Representation - Able Marine Energy Park

Reference No.ABLE - 0010

Able marine Energy Park

Representation On Behalf of the Stone Creek Boat Club

Figure 12 Predicted increases in potential sedimentation and erosion after a modelled spring neap cycle (Run 43)

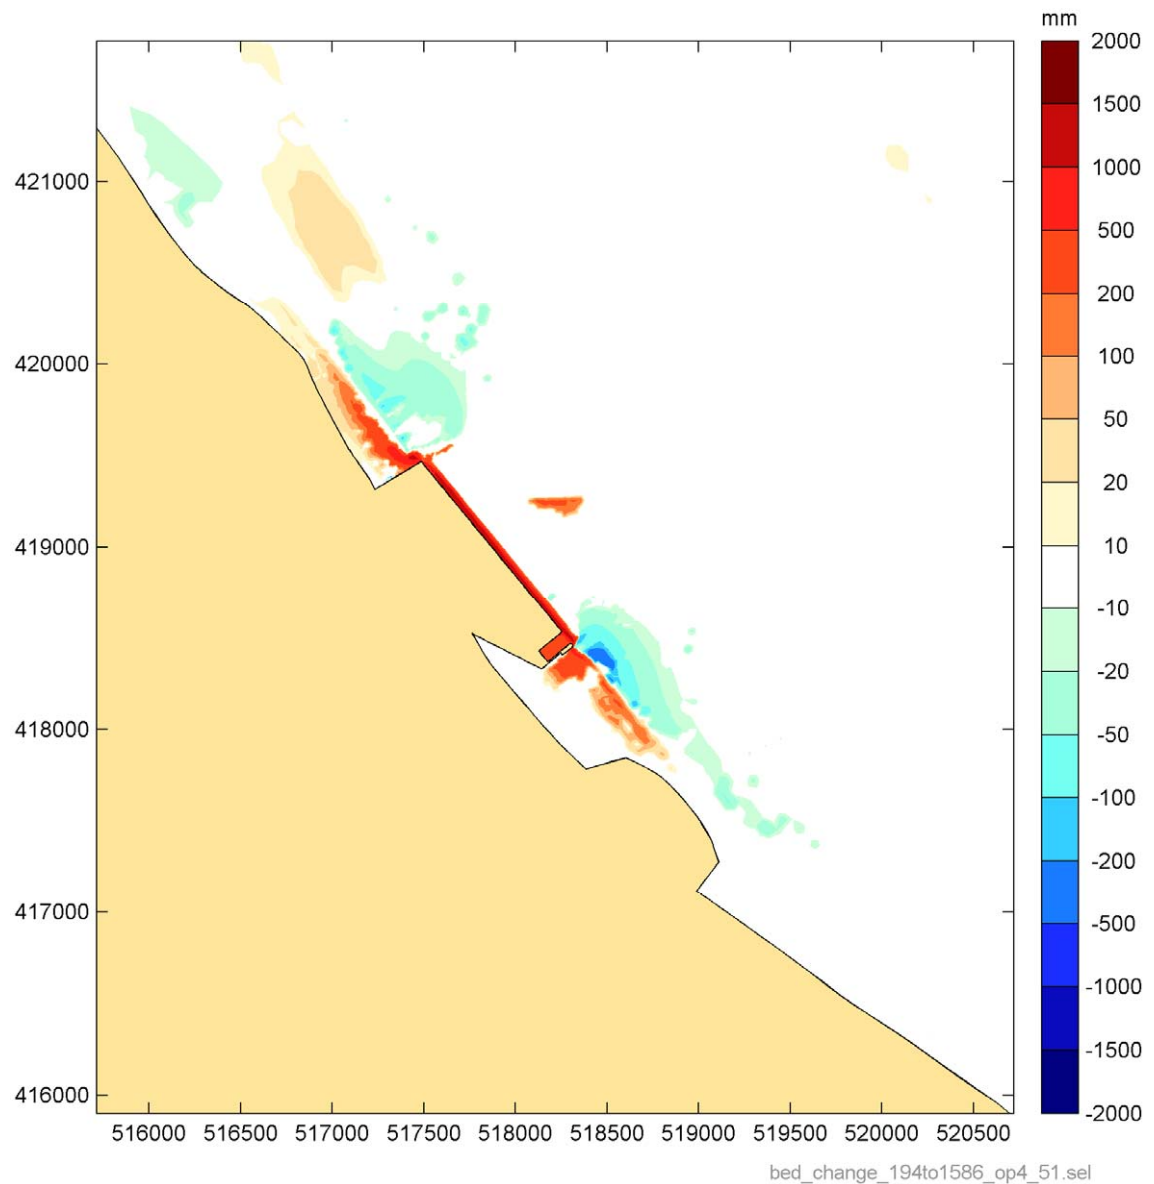
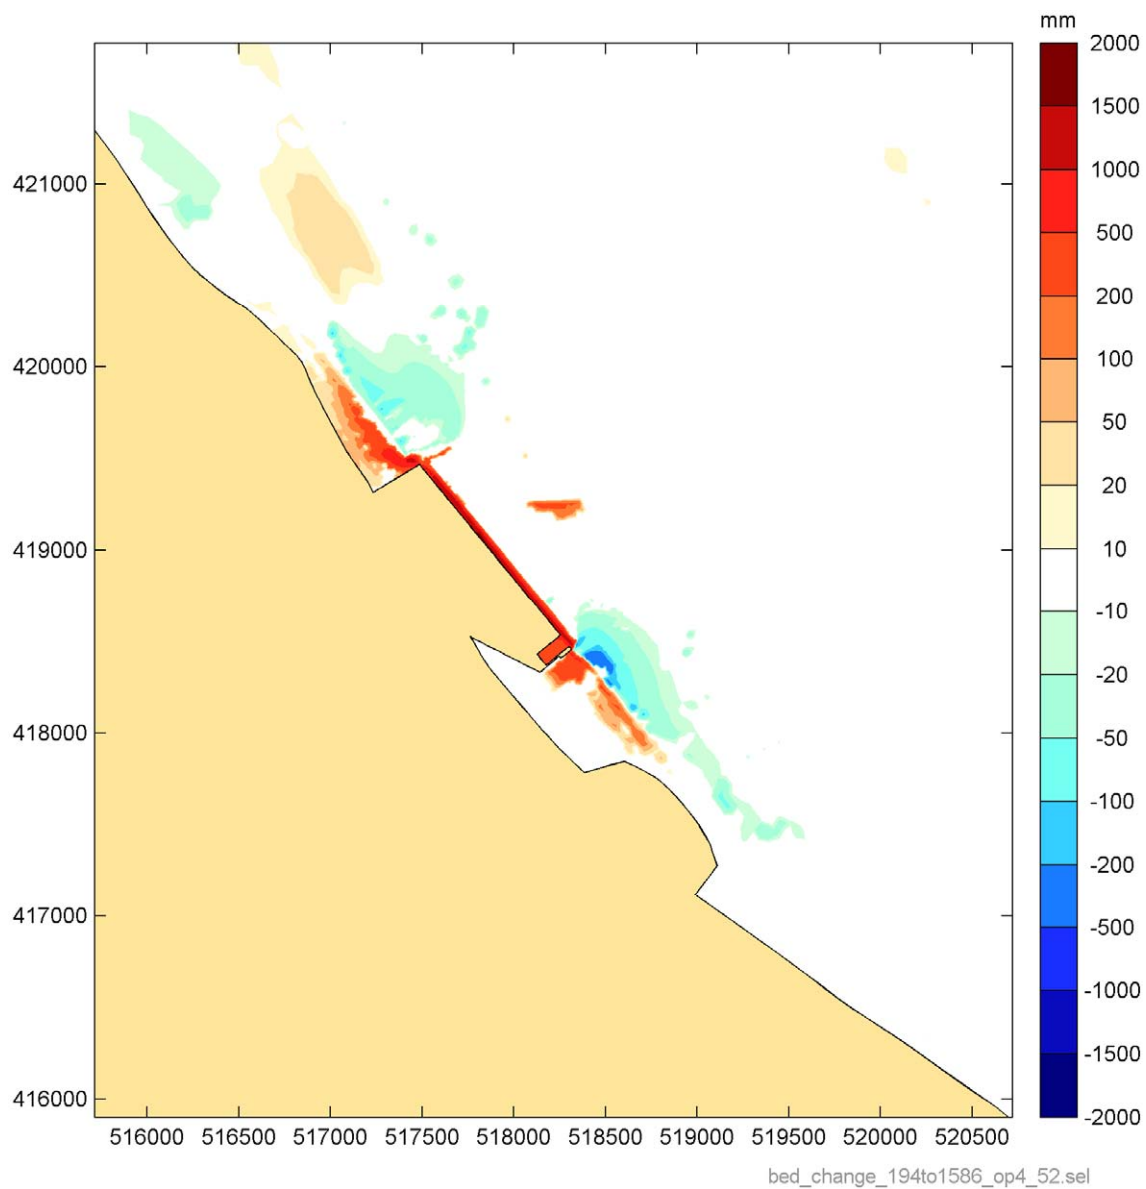
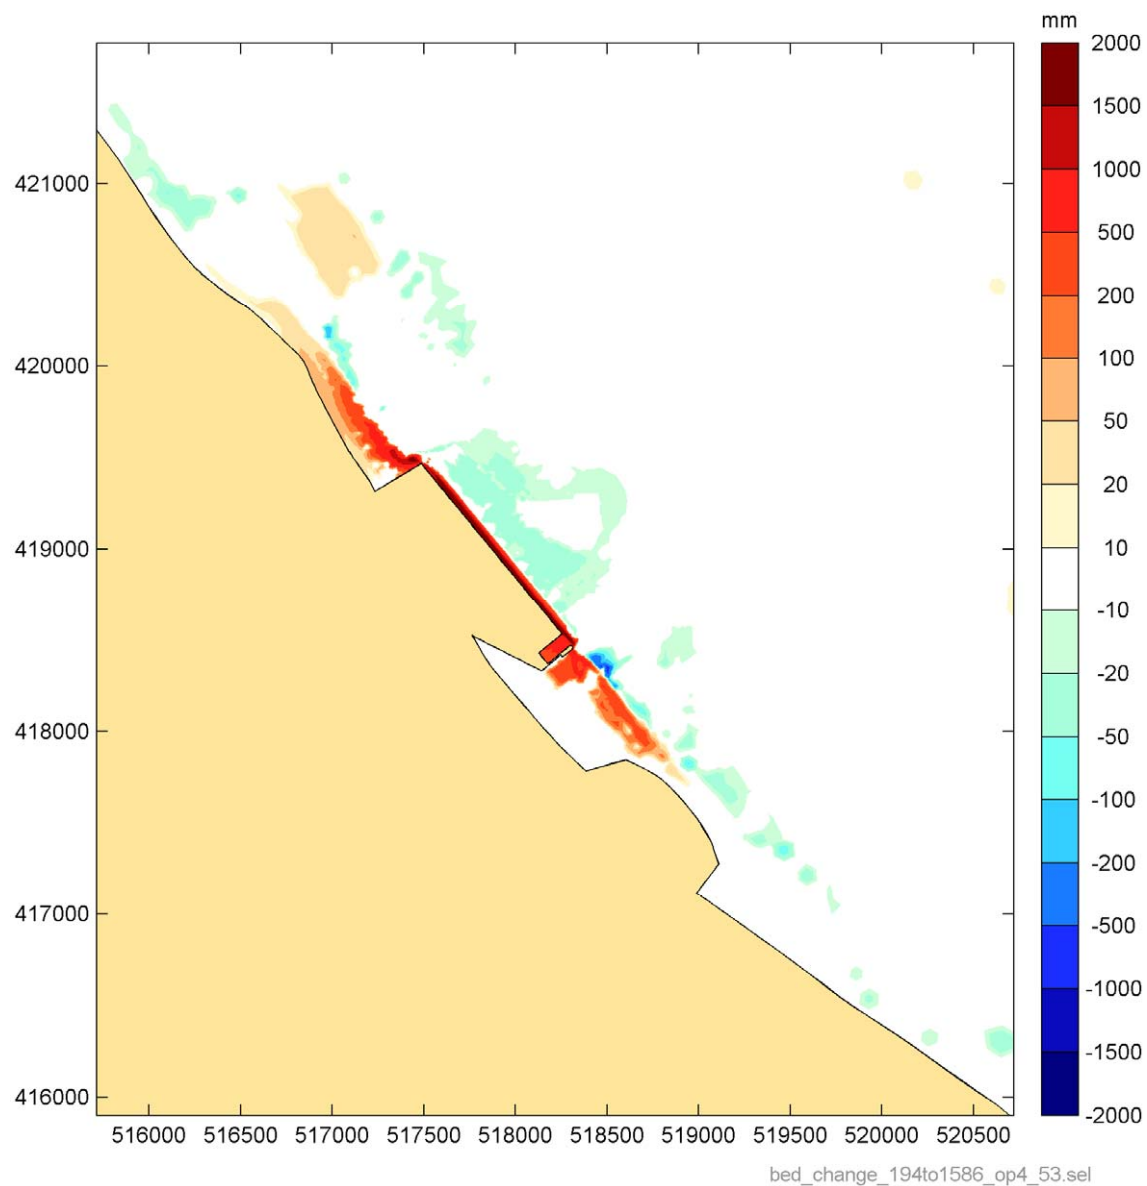
Black and Veatch have made extensive use of a computer model to predict outcomes at Stone Creek and the inner Channel. There is almost no printed data available on the tide flows, water depths and silt accretion in the study area. The developer has not made any site measurements to collect data in support of the model. We therefore question the validity of the model and usefulness of the predicted outcomes.

The model has been run on very selective tide levels insufficient ranges have been used to give a comprehensive outcome.

The Black and Veatch report acknowledges, but does not go into any detail possible increases in sedimentation at Stone Creek + the Battery (known locally as) 4.5.4 Given the significant impact any build up of silt will have on these two area's consideration given by the developer is woefully inadequate.

The larger volume of water passing the Stone Creek out fall is likely to produce a high mud bar further impeding navigation. The Black and Veatch report gives an error in predicting sedimentation of + or - 50%. Given the dire consequences of increase silting the adequacy of the Black and Veatch report is not acceptable.
